## Application for Removal or Variation of a Condition following Grant of Planning Permission or Listed Building Consent

18/02159/FUL

CONDITION 9

PLANNING DRAWING
HOUSE 4 PROPOSED NORTH EAST ELEVATION | PLANNING DRAWING HOUSE 4 REF. D23-A3 REV A |

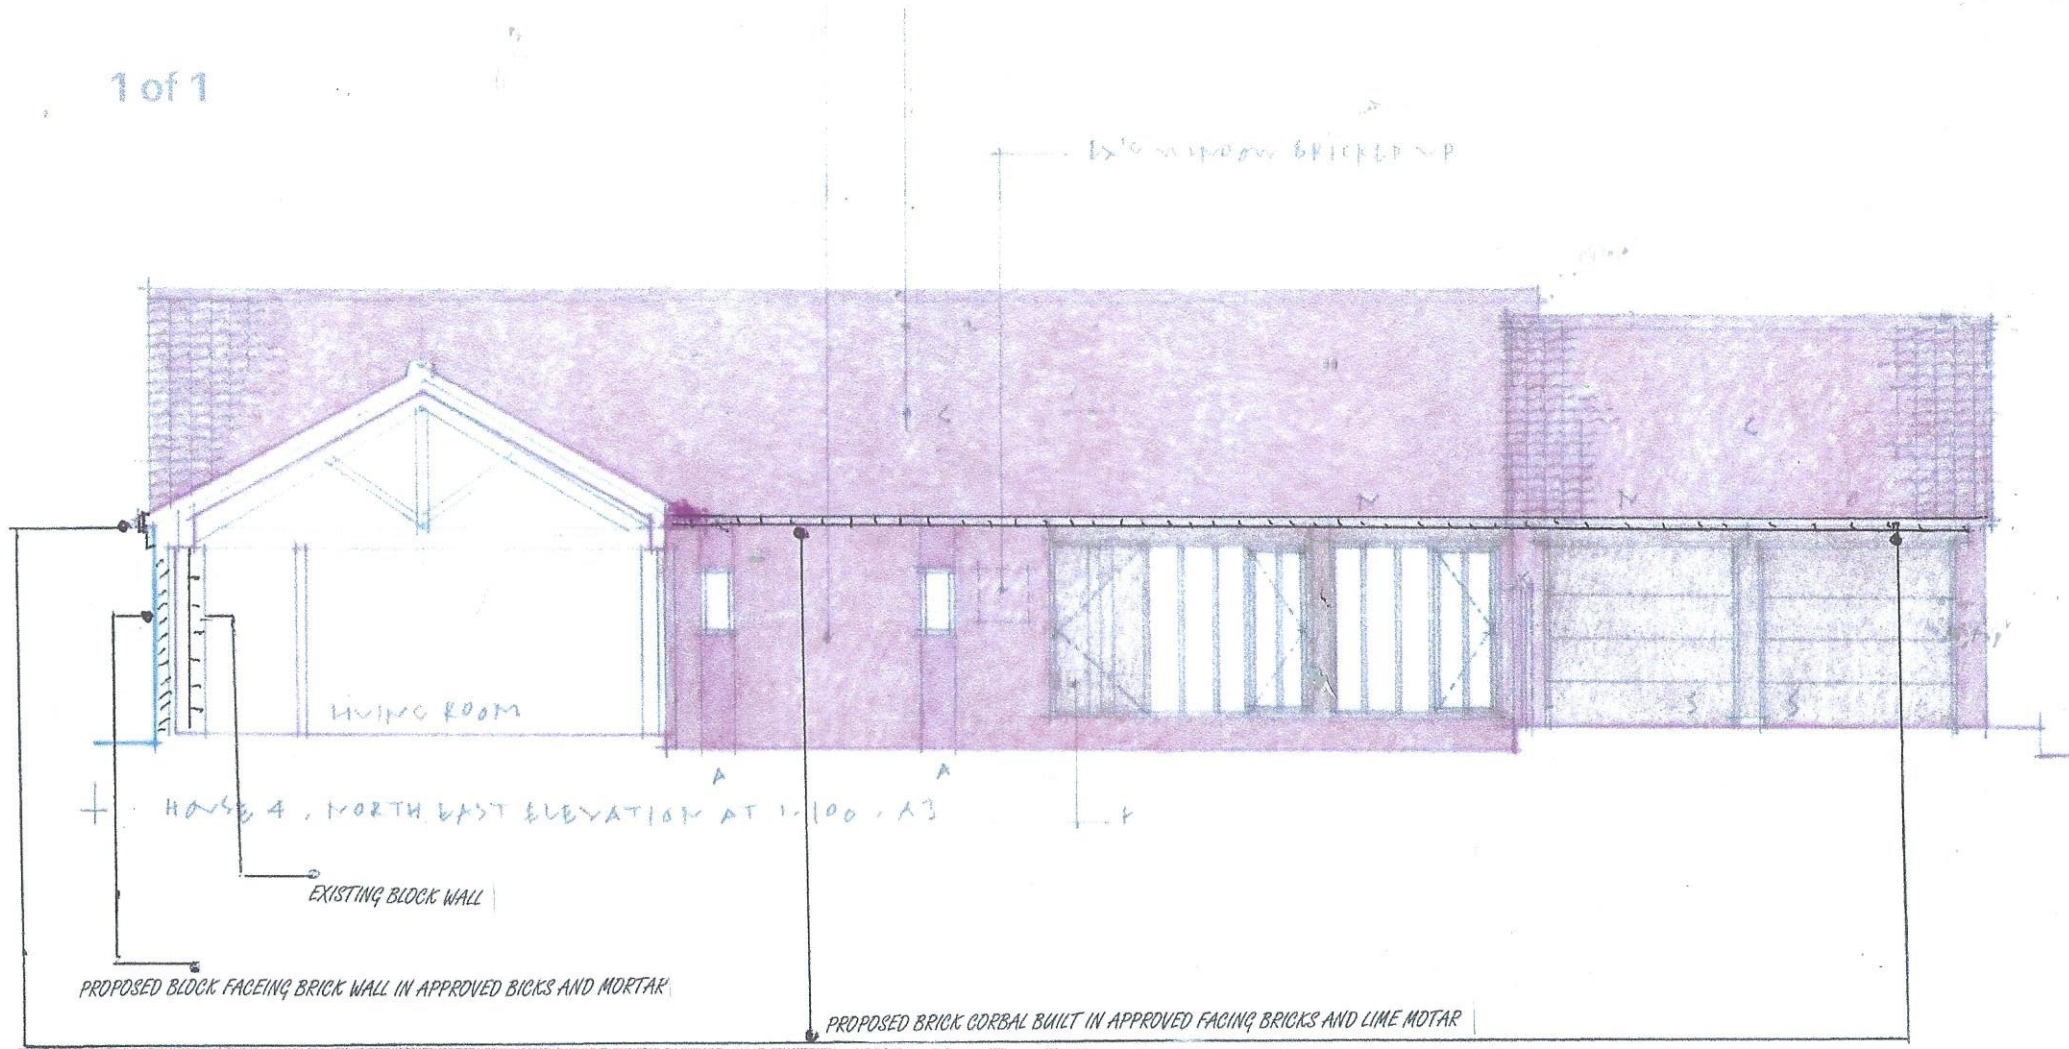
The South East Elevation shown on approved Drawing No. D21- A3 Rev B makes reference to the brickwork being 'retained and repaired'. However this elevation is constructed from concrete blockwork rather than brickwork, and this is visible externally. We would request through this submission (as discussed at our onsite meeting) that we be allowed to add a reclaimed brick skin to the outer face of this blockwork using approved surface bricks and mortar, and tied back as required both for structural integrity and aesthetics. Additionally, we also seek approval (also as discussed at our onsite meeting) to add brick corbels to the elevation, again using approved bricks and mortar – attached drawing ref D23 - A3 Rev A as the current roof is incongruous timber fascia and soffits.

The roof overhang on the existing building is some 450mm on the South East Elevation. It is our intention to reduce this overhang by employing an eaves detail that matches the South West Elevation. The proposed outer skin would be constructed in facing bricks to match the existing verge and eaves details, with rainwater goods in cast effect and reclaimed roof tiles used – see drawing ADD – A1. On the North East Elevation we seek approval to perform similar remedial work as that requested for the South East Elevation. We propose to add brick corbels the same as those proposed on the South East Elevation, using approved bricks and mortar, and we would also seek approval to add a brick skin wall to the existing block wall at the building end furthest from the road – see drawing ref D23 – A3 Rev B.
